**Consultation Response from KC,
Lead Local Flood Authority**

**2025/93273 land northwest of, Urban Terrace, Denby Lane, Grange Moor, Huddersfield, WF4
4EB**

**Discharge of details reserved by conditions 10 (attenuation), 11 (surface water), 12 (parking), 14
(visibility splay), 15 (access), 16 (footway), 21 (sewer) on previous permission 2023/93704 for
erection of 12 dwellings and associated works**

**Date Responded: 31st December 2025
Responding Officer: Paul Farndale
Responding Ref: 1**

Title: **S104 LAYOUT**

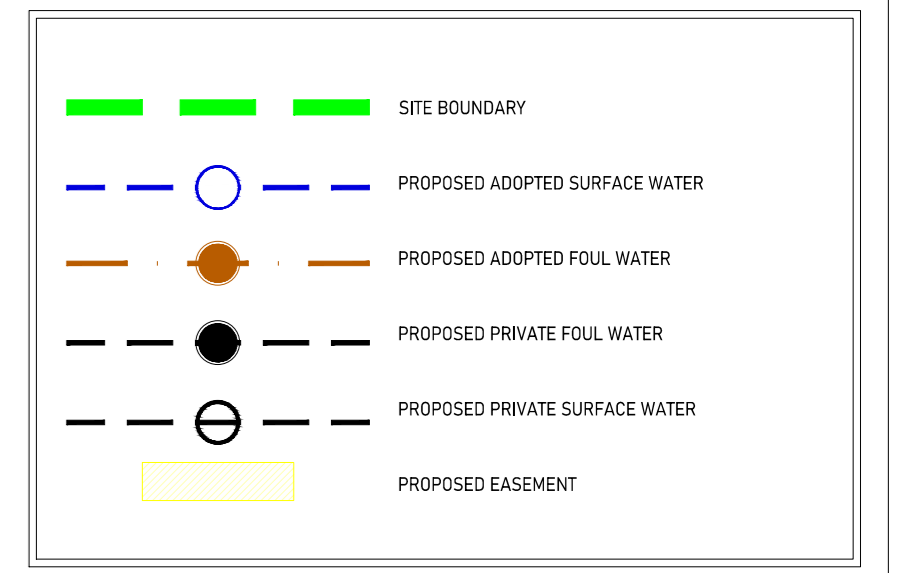
Minor alterations are required. Catchpit manholes are recommended immediately upstream of the attenuation tank and to be specifically mentioned in the maintenance plan for clearance.

STATUS	FOR APPROVAL
DRAWING TITLE	Proposed Attenuation Tank Details

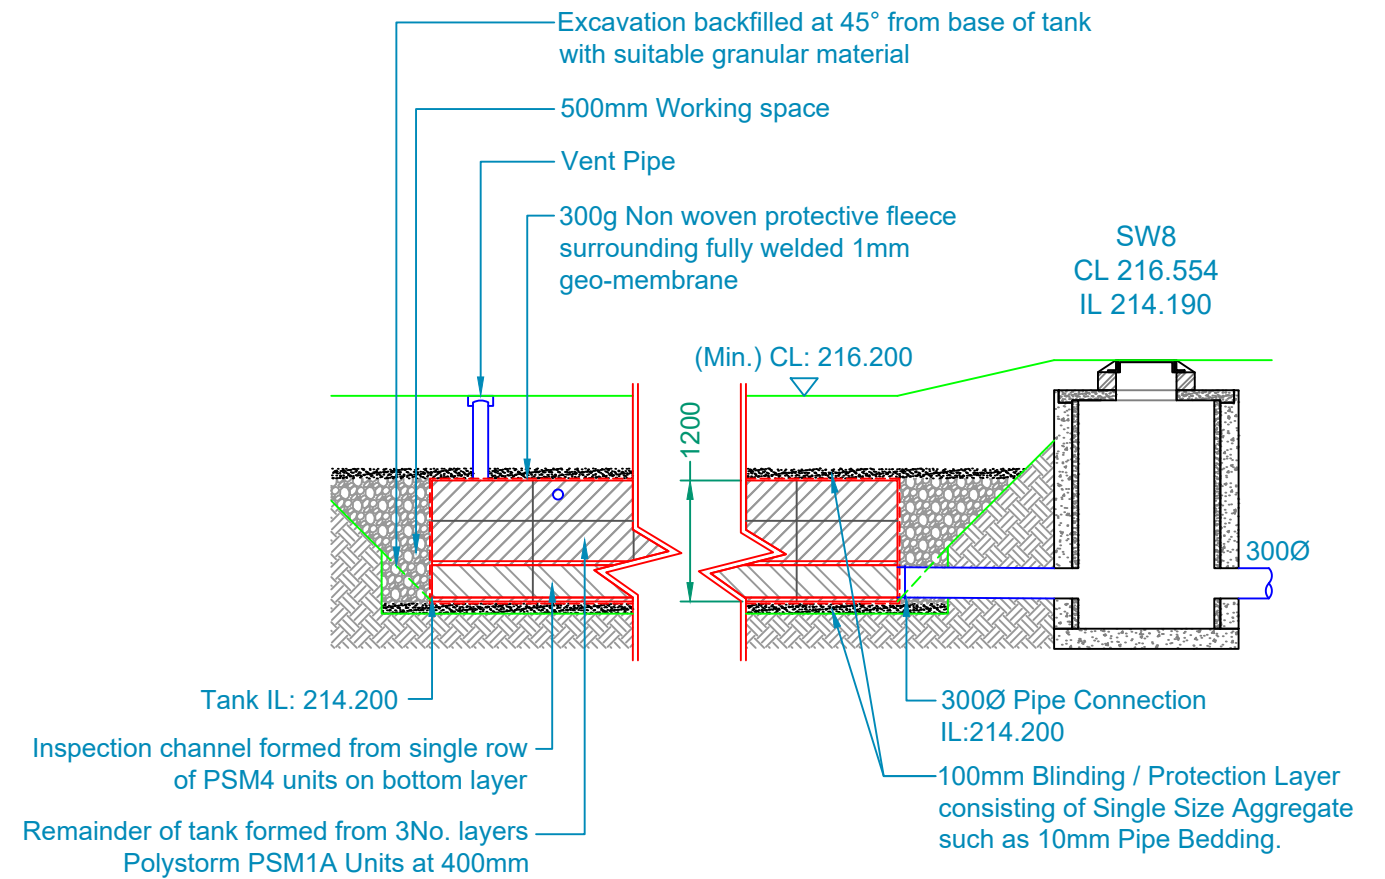
It is unclear if base units are required for the length of the system from incoming pipes (Polystorm PSM4).

A BBA certificate is available for Polystorm R which stipulates a lifespan for the product as does its own creep testing. The replacement attenuation tank requirement therefore needs to be built into the maintenance plan (60 years). This of course will not be relevant, and the plan itself rescinded upon adoption by Statutory Undertake or NAV.

It is not clear from the plan just how you would be able to survey the crate storage and remove silt. There is no mention of proprietary access points on the crates themselves.

Minor Alterations are required. We cannot recommend discharge at this point in time.
